From: david.west [REDACTED]
Sent: 11 July 2017 16:30
To: Slingo, Bradley; clare.may
Cc: Kennett, Darren
Subject: *EXTERNAL: RE: Westergate, Hook Lane - Statement of Detail - Lighting

We have submitted a 'statement of detail' with external lighting details to ADC. Claire Potts has had the following response:

AL/11/17

15. Floodlighting and security lighting.

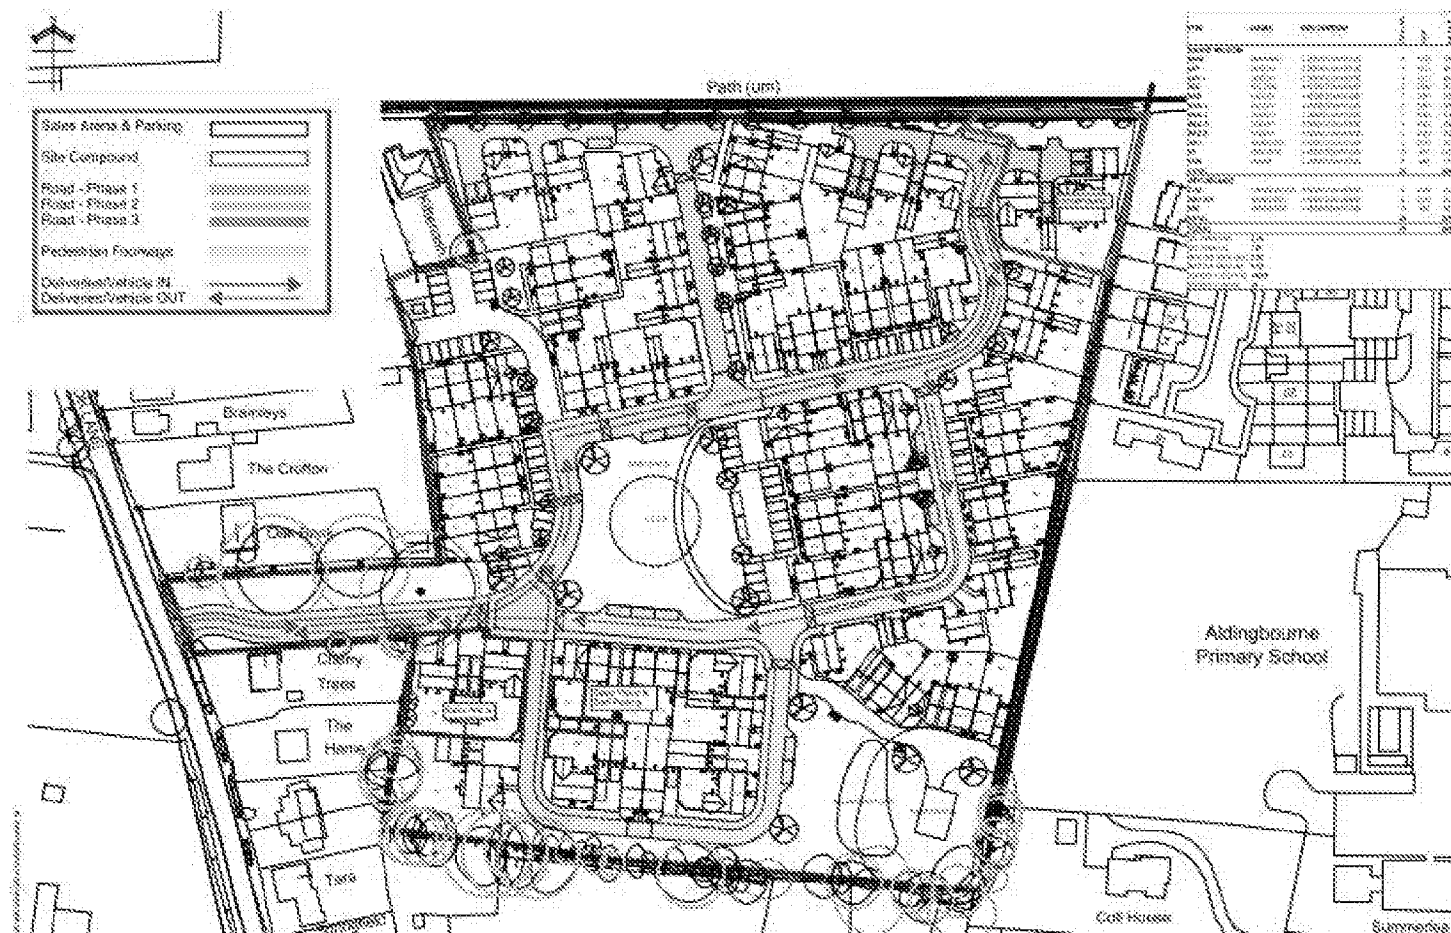
Are these security lights, i.e. motion activated?

Please can you confirm that these lights will not have a negative effect on bats within the local area. Please indicate any additional information you require to provide a response. The attached pictorial specification shows these lights but not their luminance levels.

In that case I can confirm that these lights are unlikely to result in significant disturbance of bats foraging or commuting on site due to the limited period of illumination.

These are to be PIR lights and therefore will be motion activated.

All external light fittings to be Compact Fluorescent type. External lighting including lighting in buildings is to be photosensitive to automatically extinguish when there is enough daylight. PIF
